**EPC STORMWATER REVIEW COMMENTS
IN ORANGE BOXES WITH BLACK TEXT**

**PCD-ENGINEERING REVIEW COMMENTS
IN BLUE BOXES WITH BLUE TEXT**

FINAL SITE GRADING CONSTRUCTION PLANS
FOR

FINAL GRADING / EROSION CONTROL PLANS

**THE HILLS AT LORSON RANCH
FINAL GRADING AND
EROSION CONTROL PLAN**

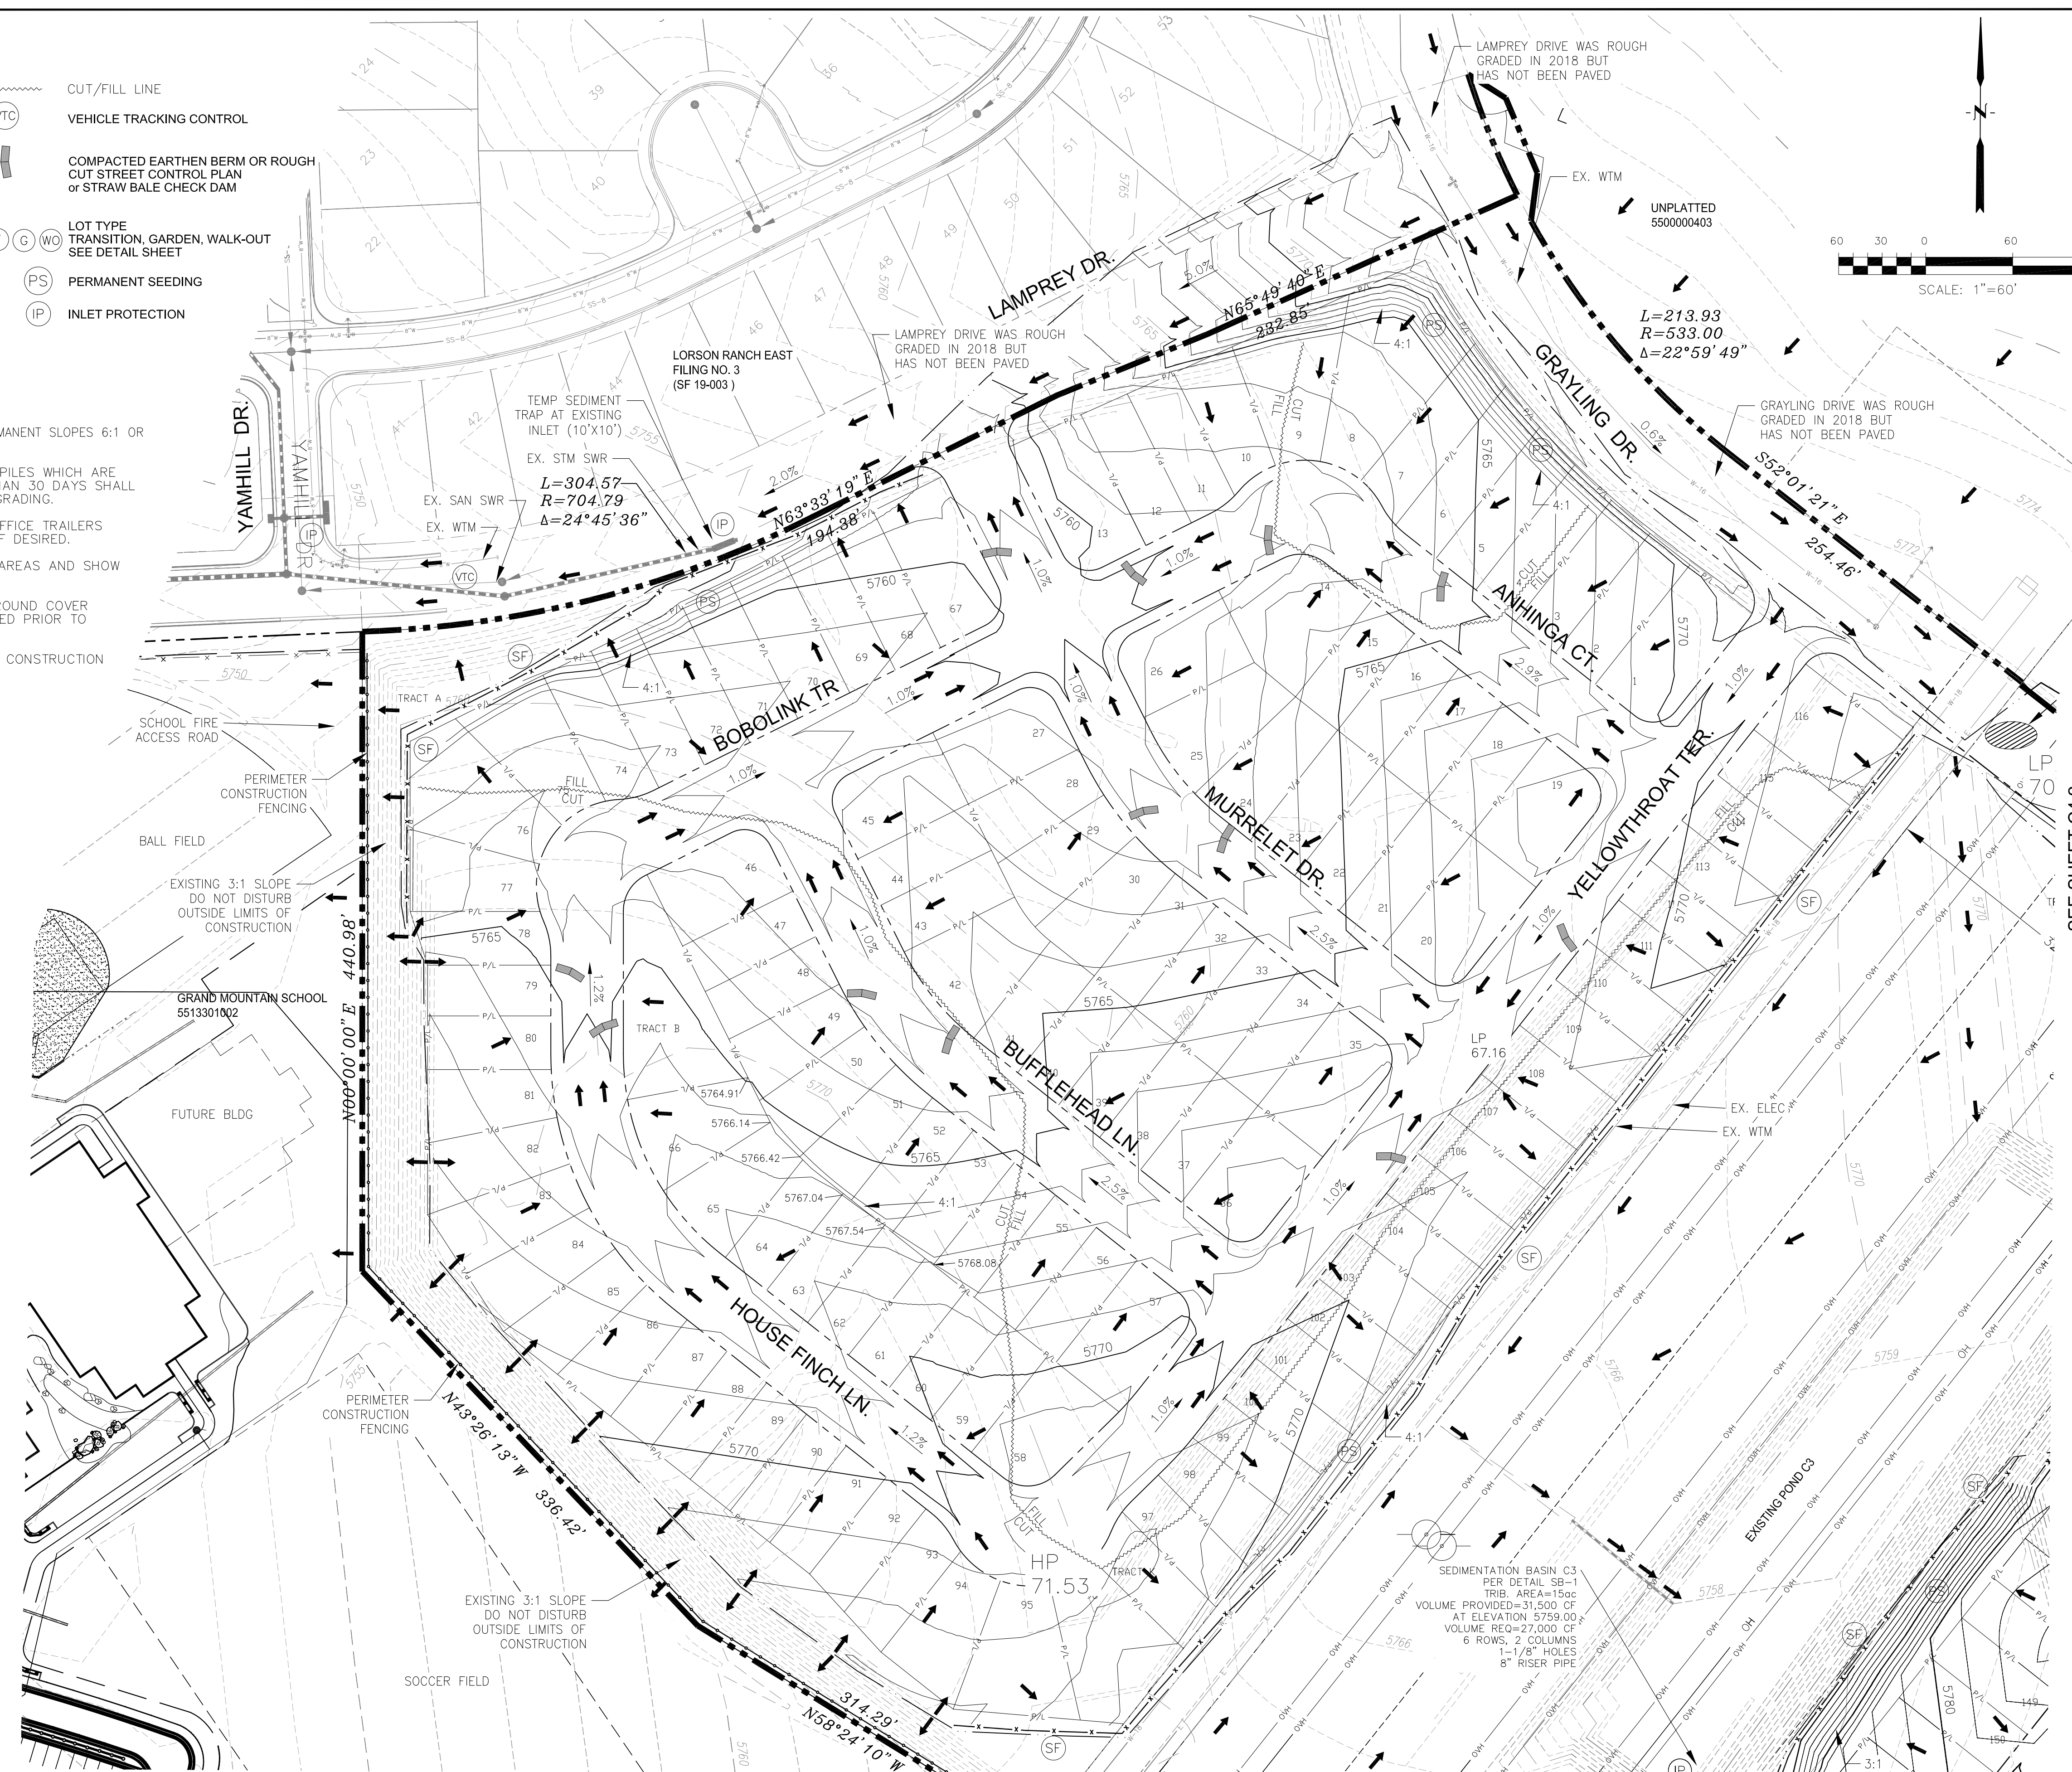
Final plat GEC Plan should show street curb & gutter, stormwater piping, and pond details for forebay and outlet structures.
Revise all sheets accordingly.

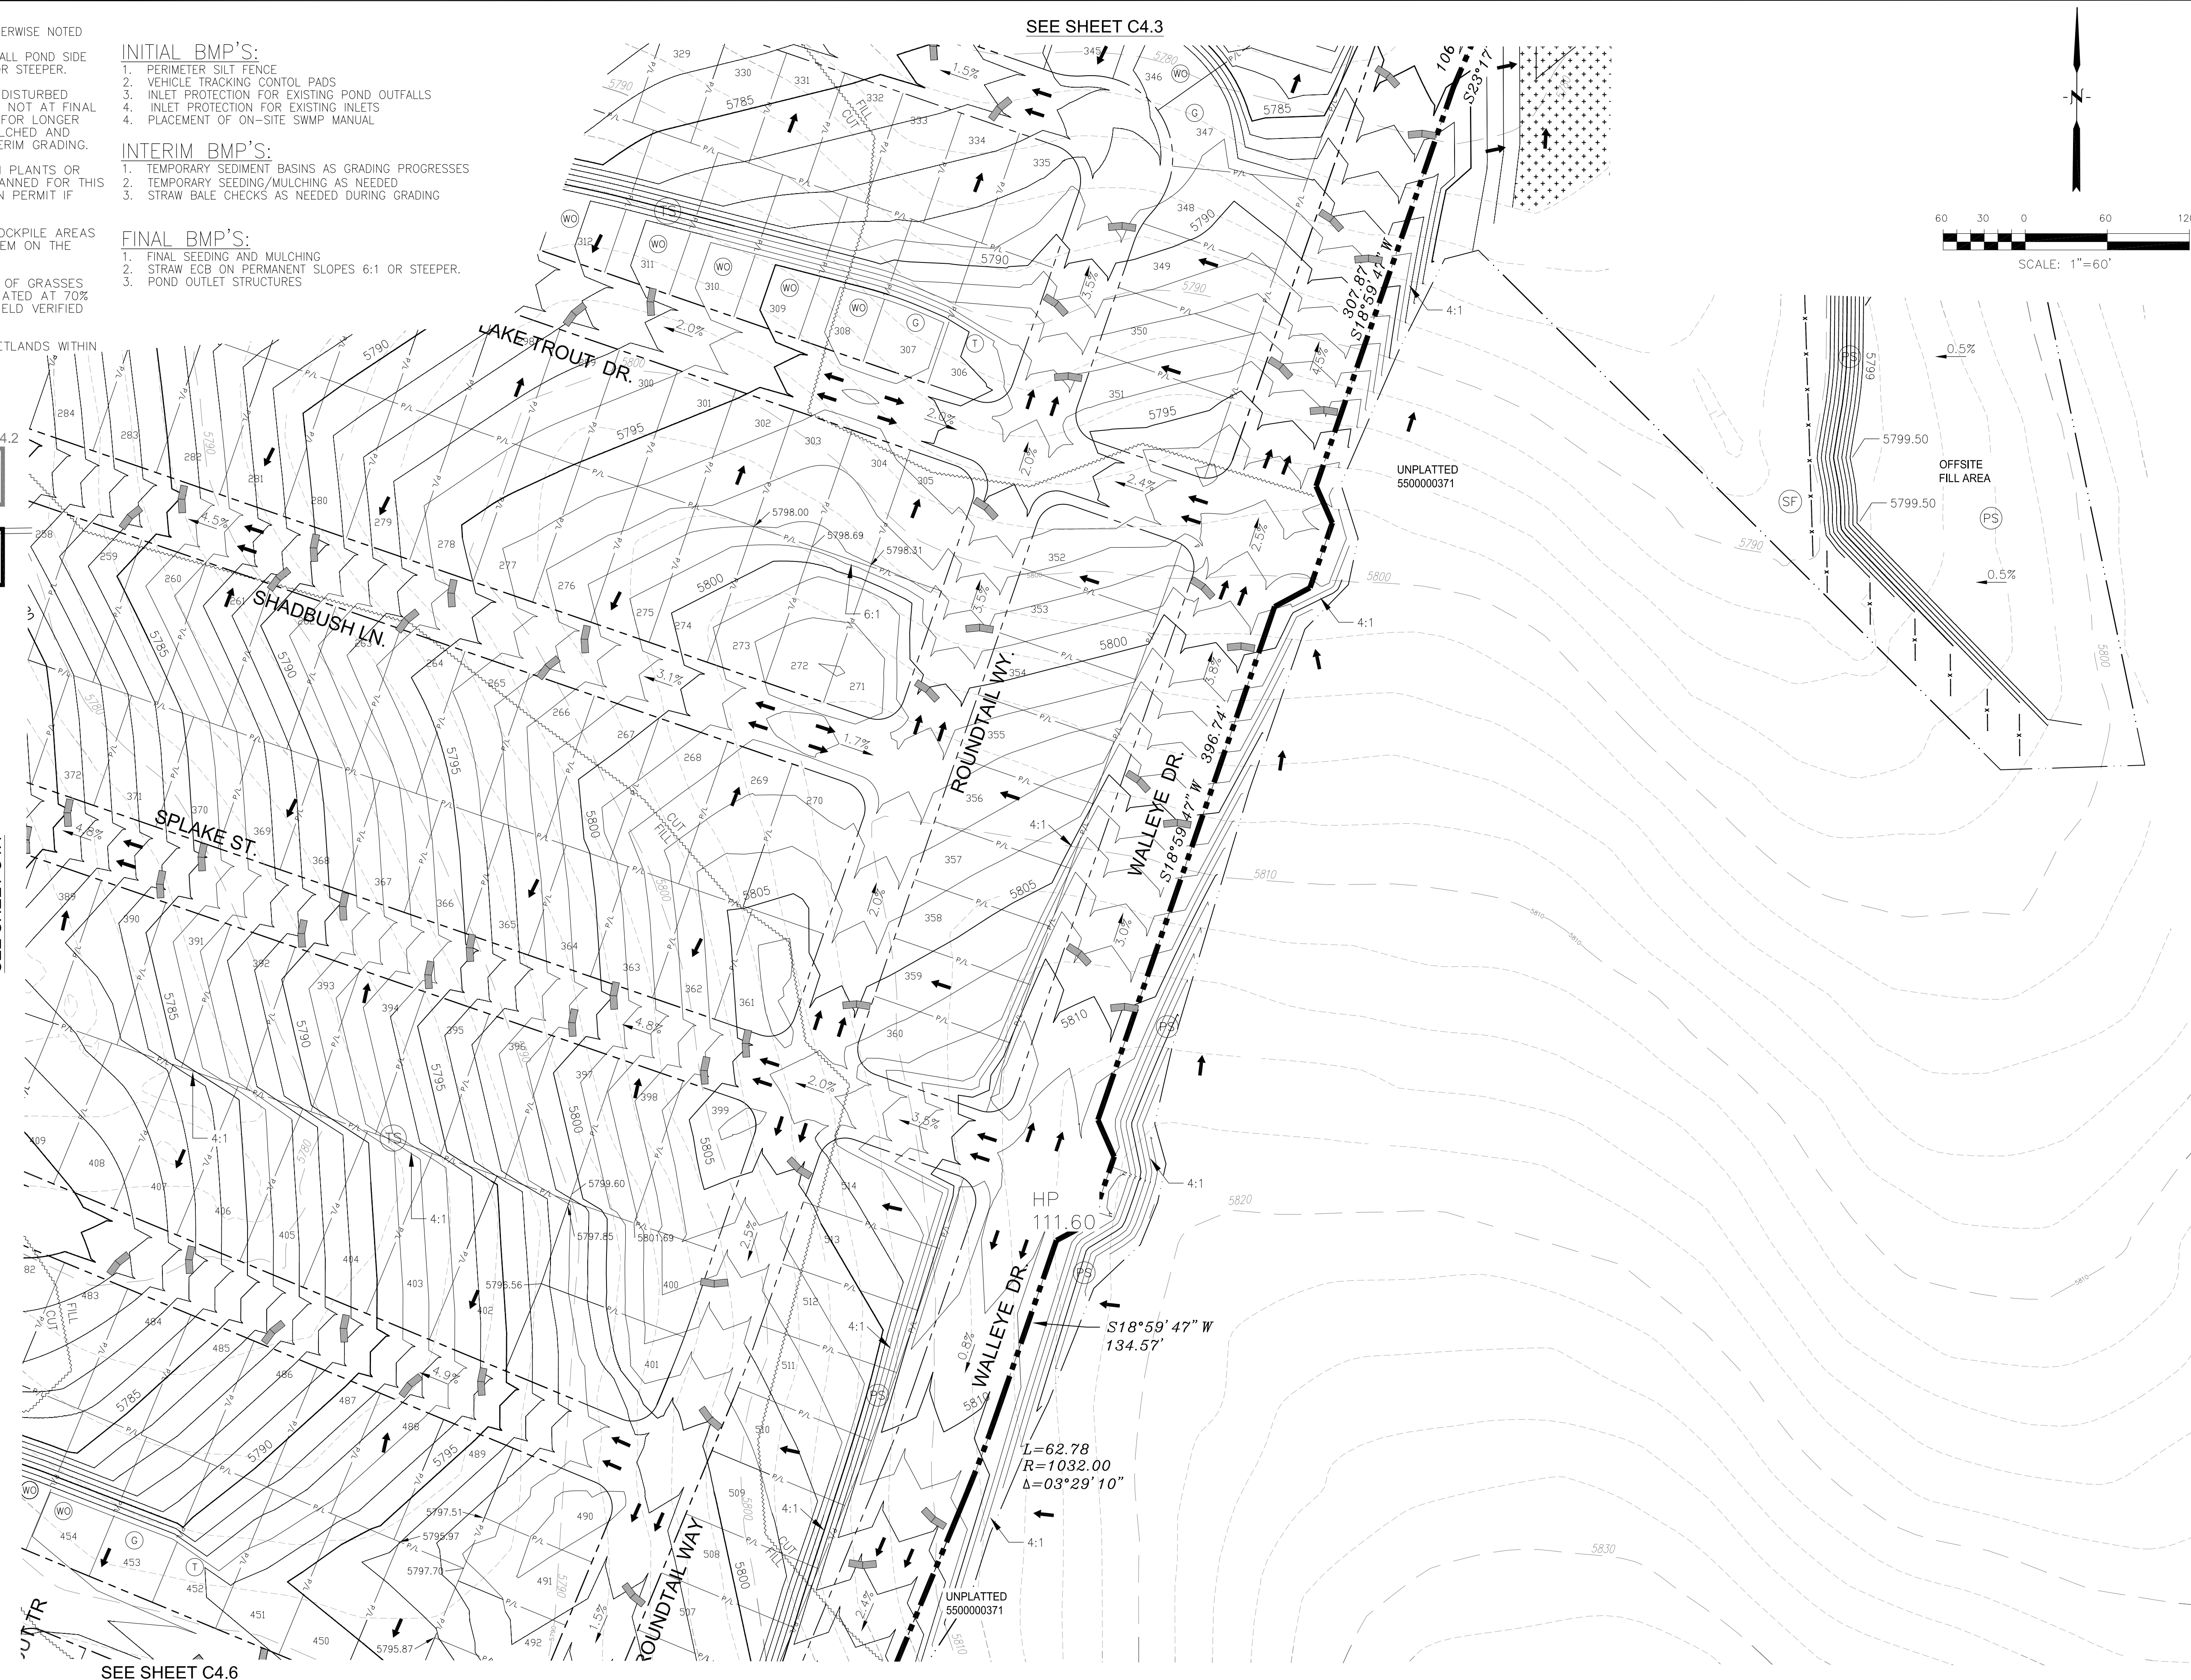
Label pond as existing?

Show and label emergency spillway for Pond C1, as mentioned on FDR page 43 of 227.
 Typical for all ponds.
 Size per UD-Detention spreadsheet.

**EXISTING POND C1 EXPANSION
 POND GRADING AND
 TRICKLE CHANNEL**

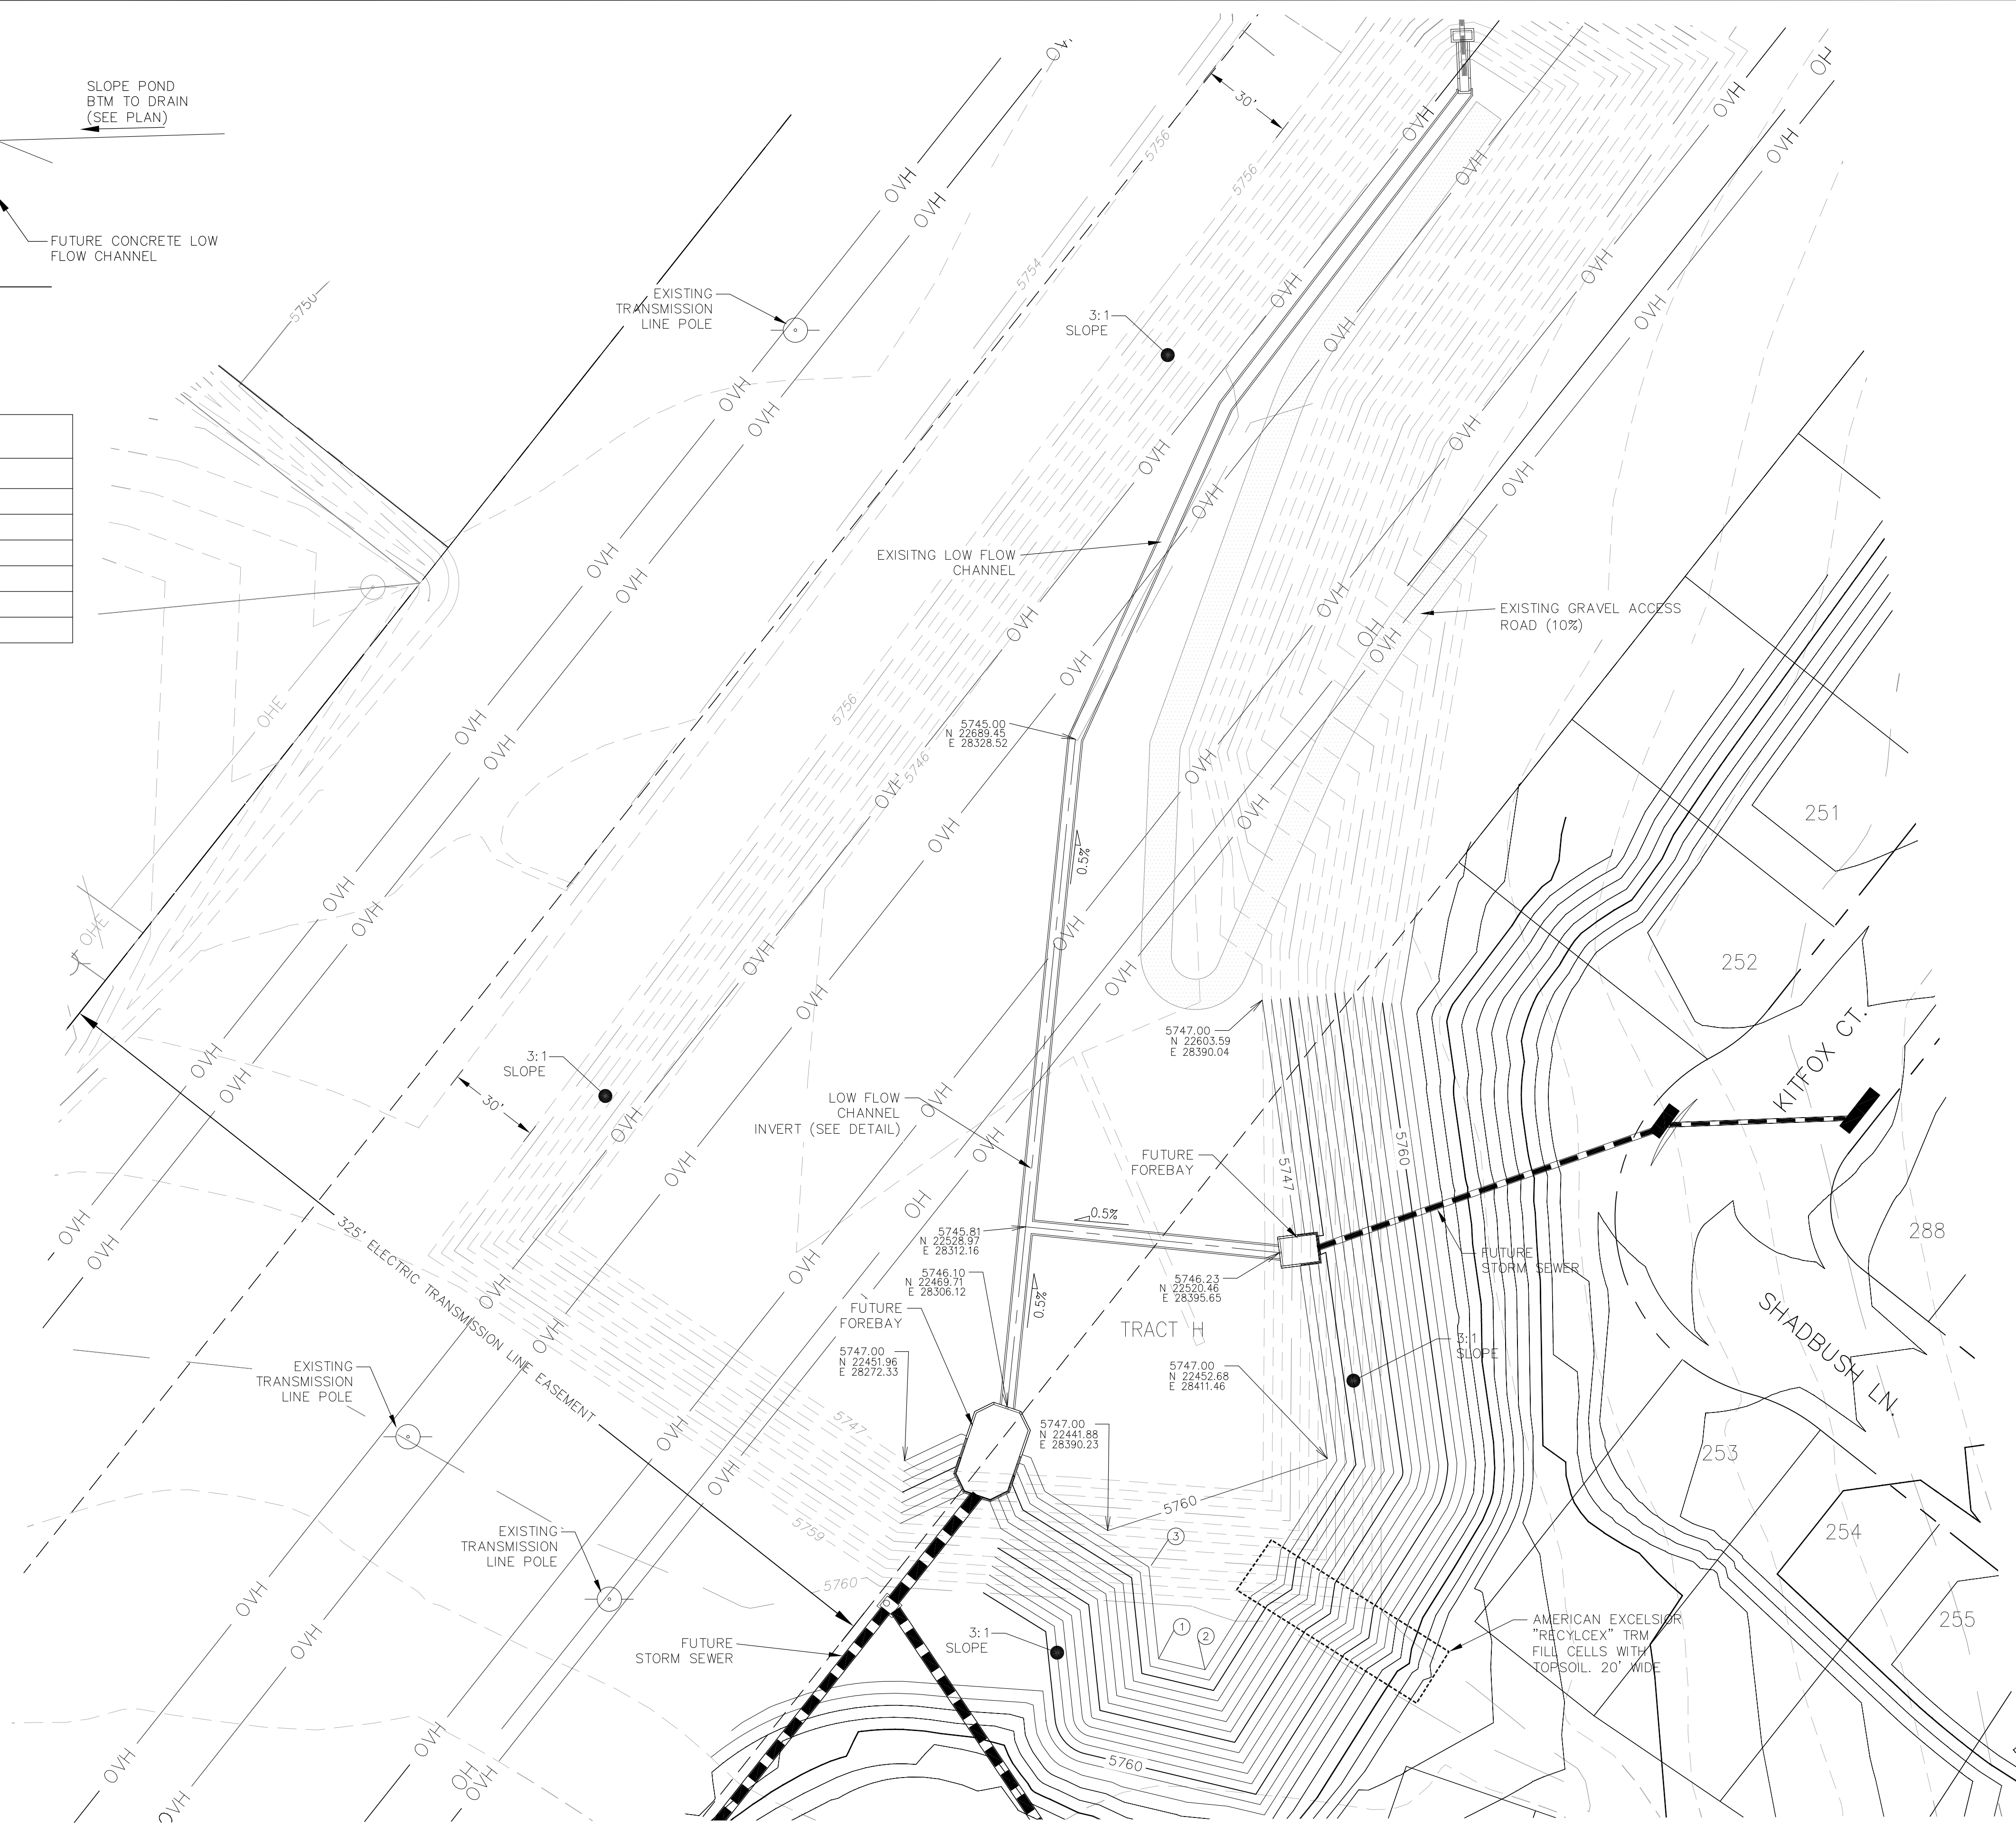
Is this sheet being revised from EGP plans? If not, reference the EGP plans with a note on the cover sheet.
